Reference: JST Accessibility Review – Access Report  
Development Application

Project: Sydney Opera House  
Joan Sutherland Theatre Accessibility Projects

Document Type: Access Report – Development Application

Report Number: IAC-333

| OT VA                    | 49-VA-SC021                           | DA182                  | C A1                             |

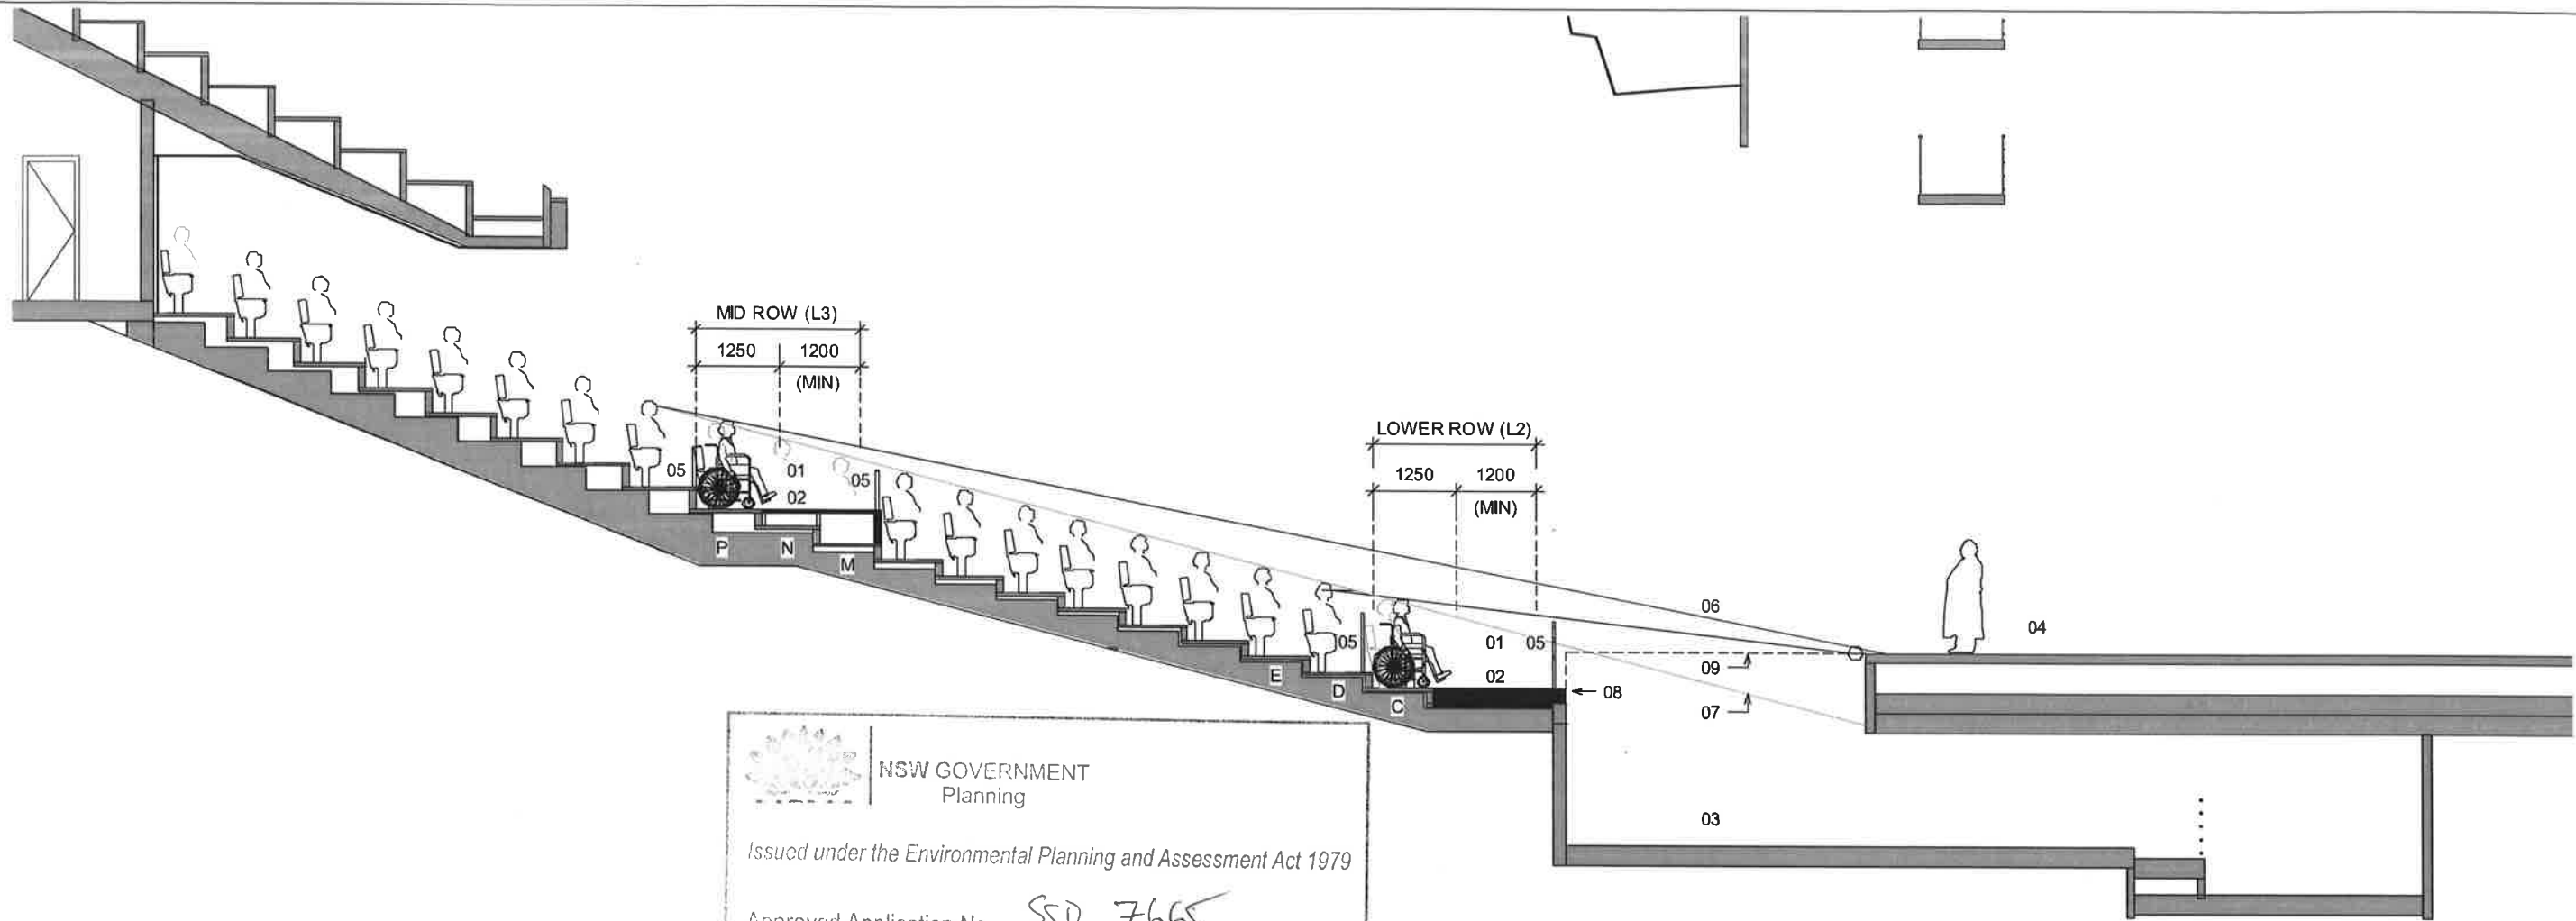
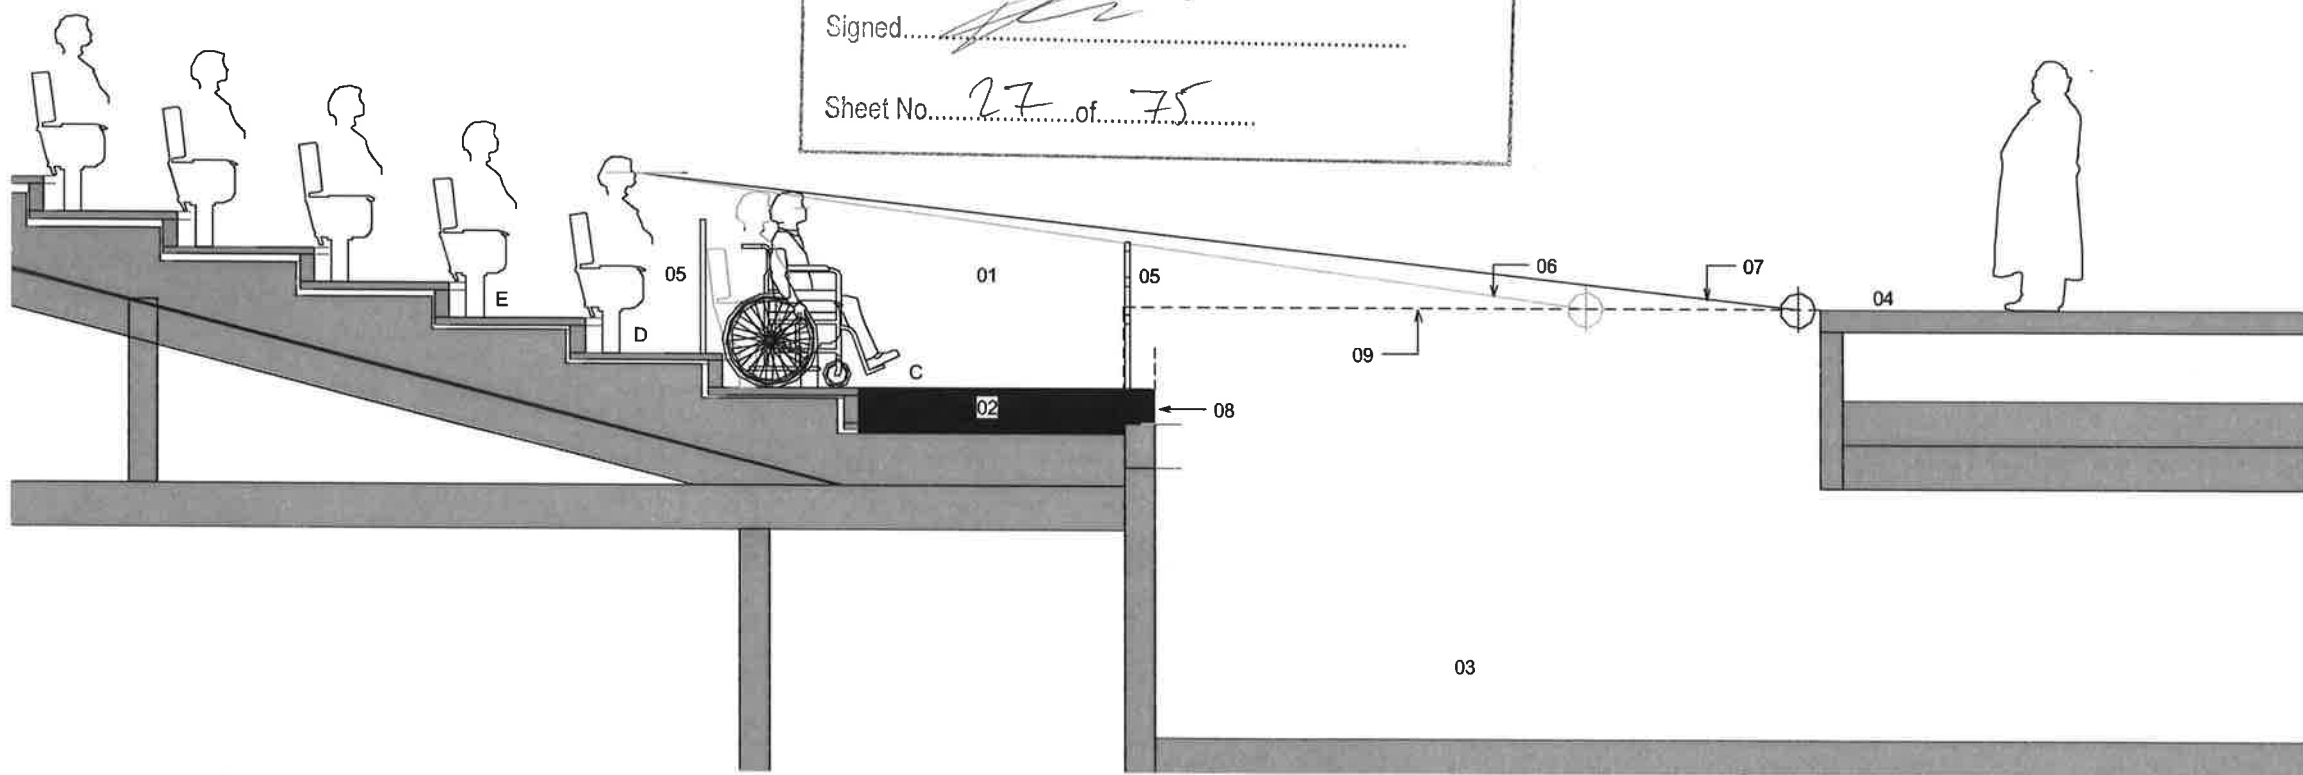
The seating rows within the Joan Sutherland Theatre affected by the works are Stalls Rows A-C and M-P. In this proposal 8 wheelchair seating locations are proposed at Stalls Rows A-C and 15 wheelchair seating locations at Stalls Rows M-P. No wheelchair accessible seating is proposed for the Loge or Circle sections of the theatre.

In this proposal it is proposed to provide the wheelchair seating on demand by the removal of fixed seating.

The spatial arrangements and grouping proposed for the wheelchair seating spaces satisfy the provision of NCC Table D3.9 and Clause 18 of AS1428.1:2009.
